From: Adrian D'Cruz <[REDACTED]>
Sent: 29 March 2022 15:40
To: Simon Davis
Subject: RE: AW/47/22/DOC Carlton Avenue
Attachments: Carlton Avenue CEMP Report 290322.pdf

From: Simon Davis <Simon.Davis@arun.gov.uk>
Sent: 22 March 2022 13:26
To: Adrian D'Cruz <[REDACTED]>
Subject: AW/47/22/DOC Carlton Avenue

Construction Environmant Management Plan (CEMP) at 1 : 5 0 0 s c a l e

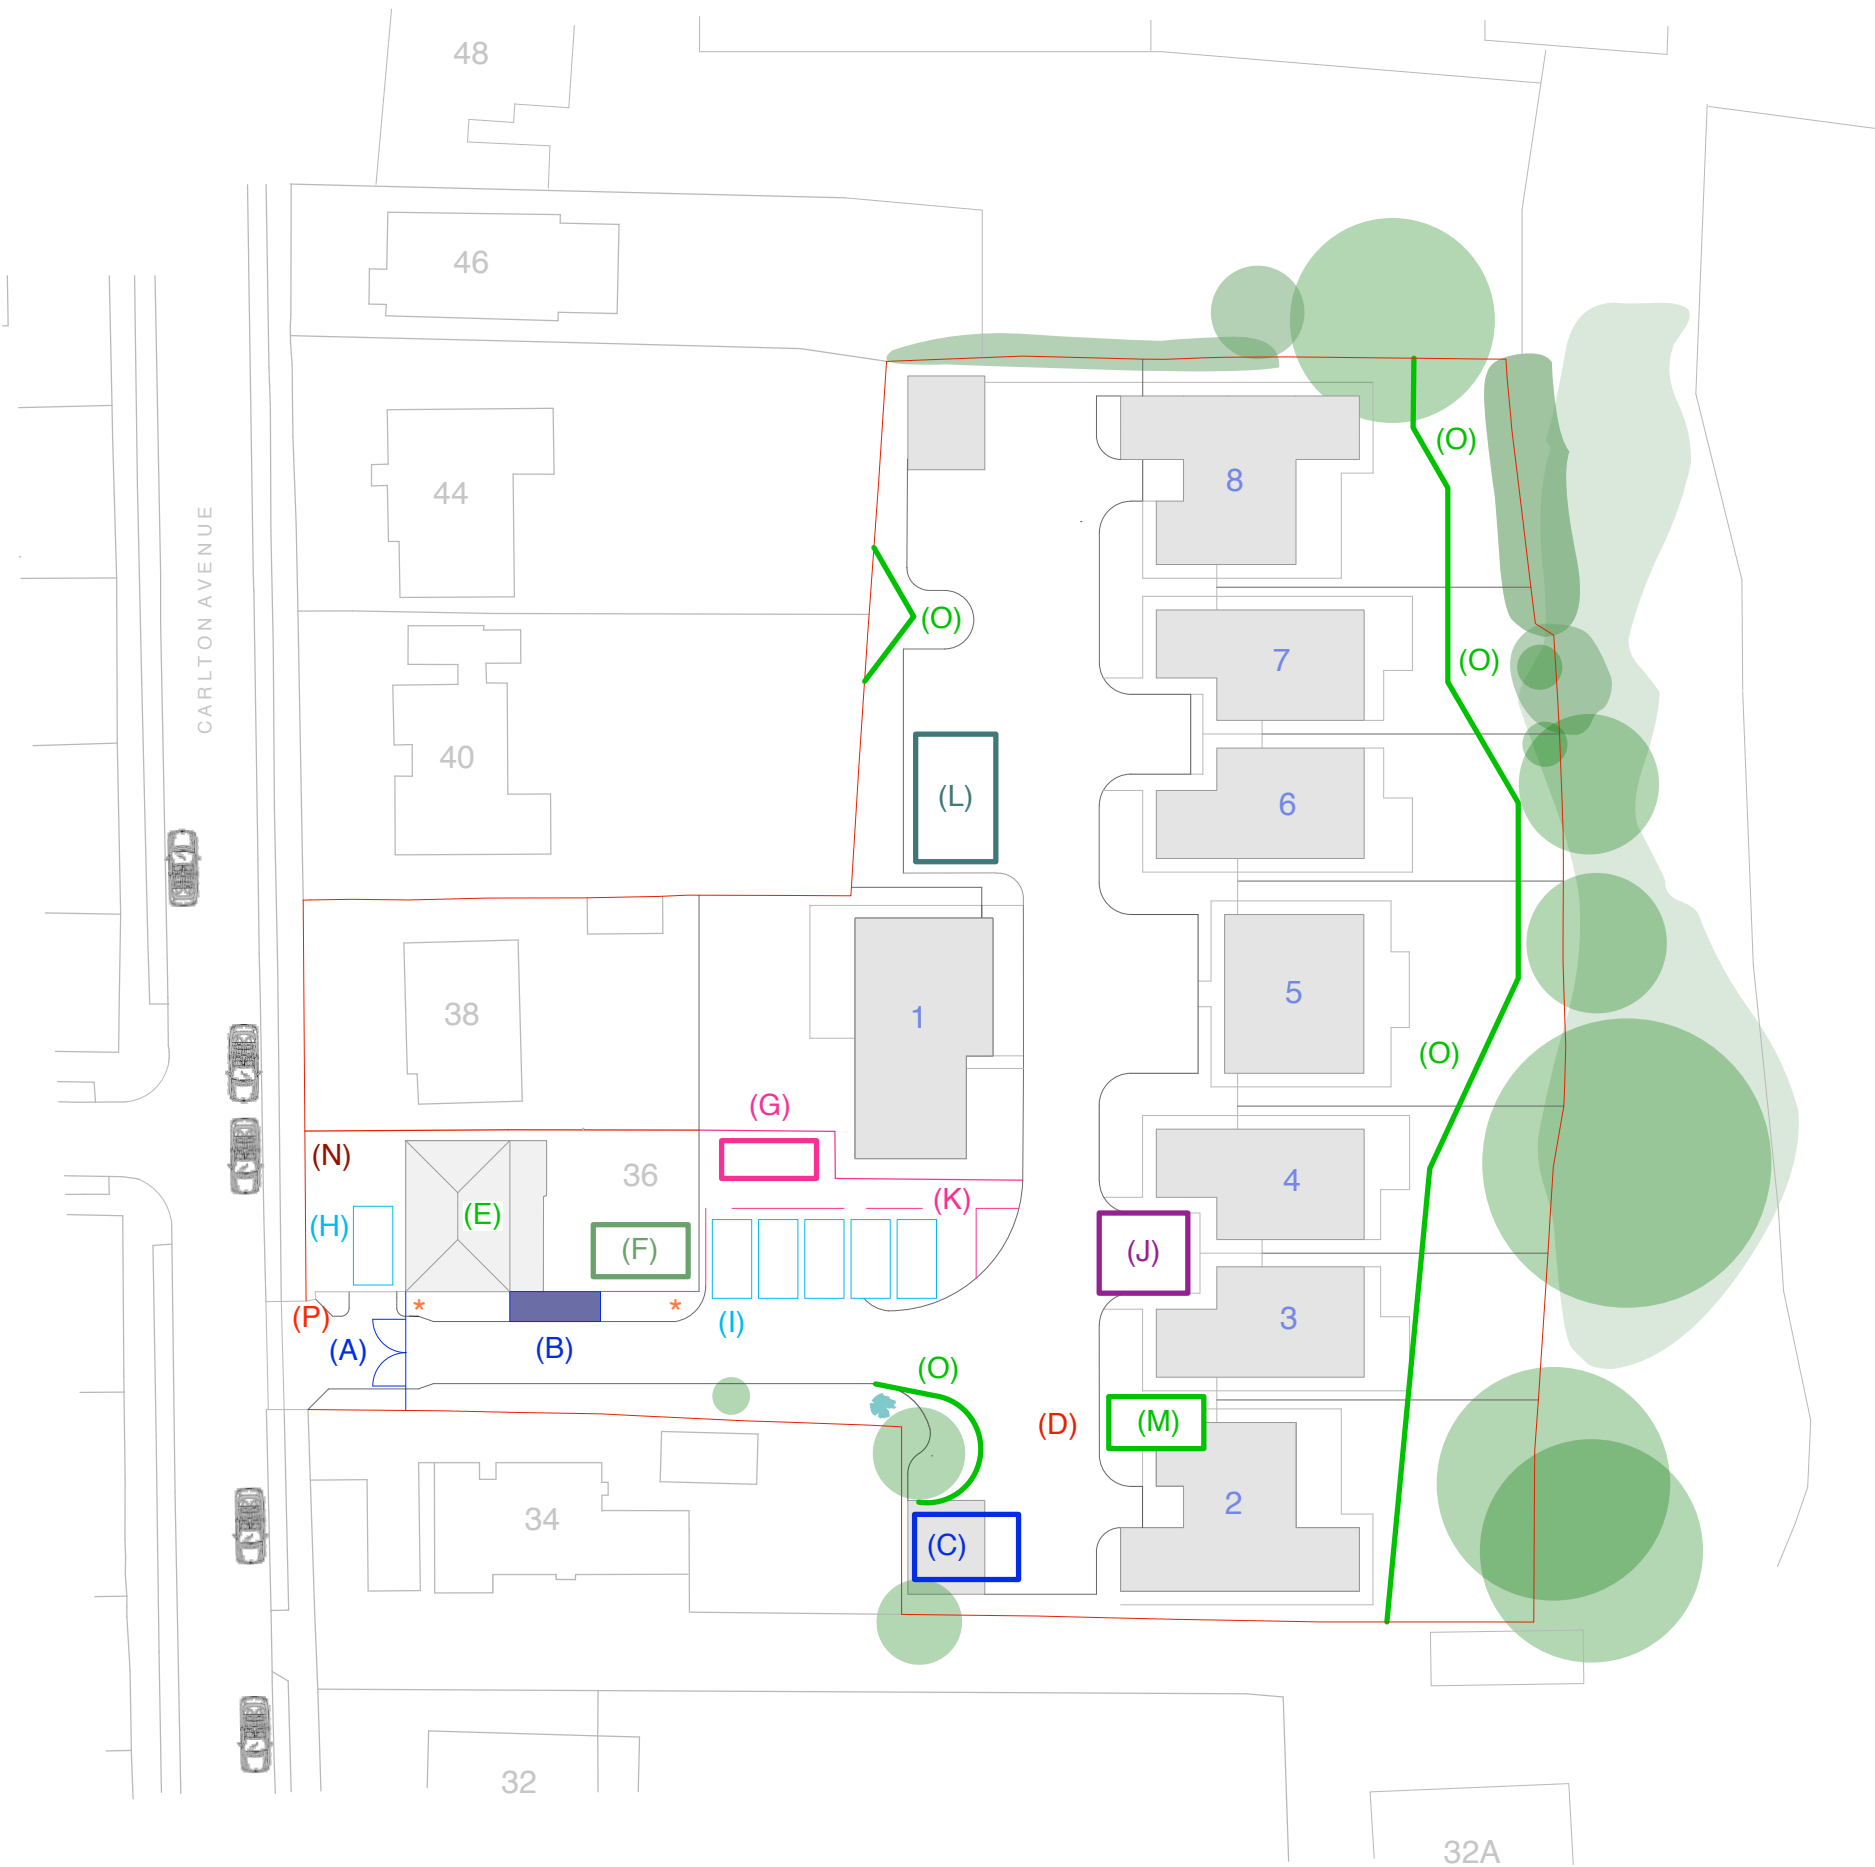
Given the proximity to the Primary School and the parking demands for the area it is advised the delivery school operating times are checked as schools often finish at 3pm. If this is the case and considering the demand for parking at school time the delivery window may have to be restricted to 9am - 2.30pm. In addition, a qualified banksman is required to managed deliveries.

There appears to be a large hedge bounding the highway to the north of the access. This will need to be removed/lowered prior to construction to allow for 2m x 2m pedestrian visibility and improve vehicular visibility.
